# GRADING AND EROSION CONTROL PLAN

## JUDGE ORR ROAD RV PARK AND STORAGE

# PPR-16-040

JUDGE ORR ROAD RV PARK & STORAGE  
COLORADO SPRINGS, COLORADO  
DRAINAGE, GRADING & EROSION CONTROL DETAIL

FIGURE OS-2 TYPICAL OUTLET STRUCTURE FOR FULL SPECTRUM DETENTION
OUTLET STRUCTURES DETAILS
NOT TO SCALE

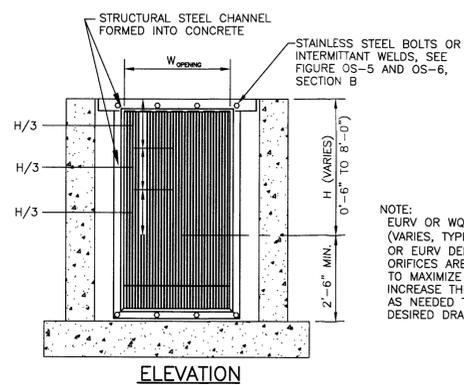
Identify the elevation

FIGURE OS-1. TRASH RACK SIZING

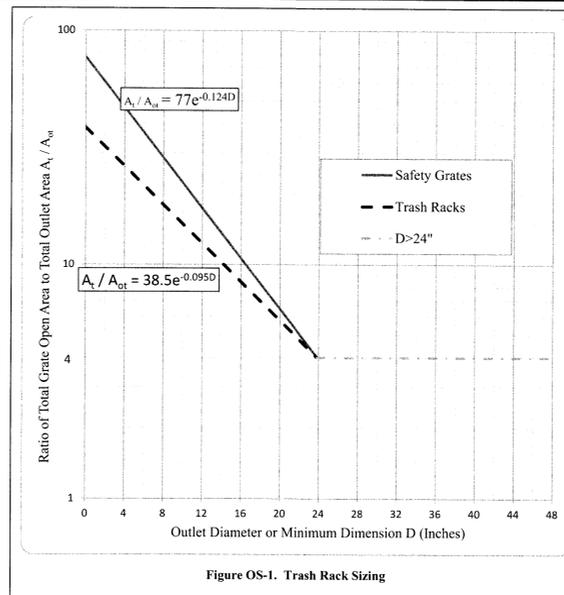
Revise. Standard convention is to identify the orifice size diameter.

FIGURE OS-5 TYPICAL OUTLET STRUCTURE WITH WELL SCREEN TRASH RACK

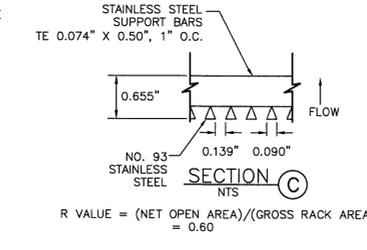
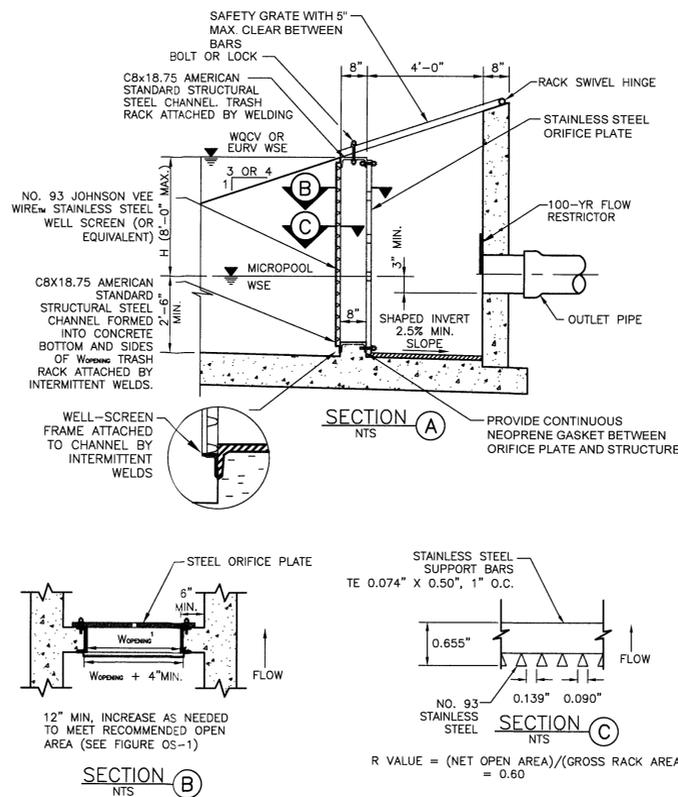
Identify the required opening. This is not left for the contractor to interpret figure OS-1.  
Remove Figure OS-1 from the construction plans.
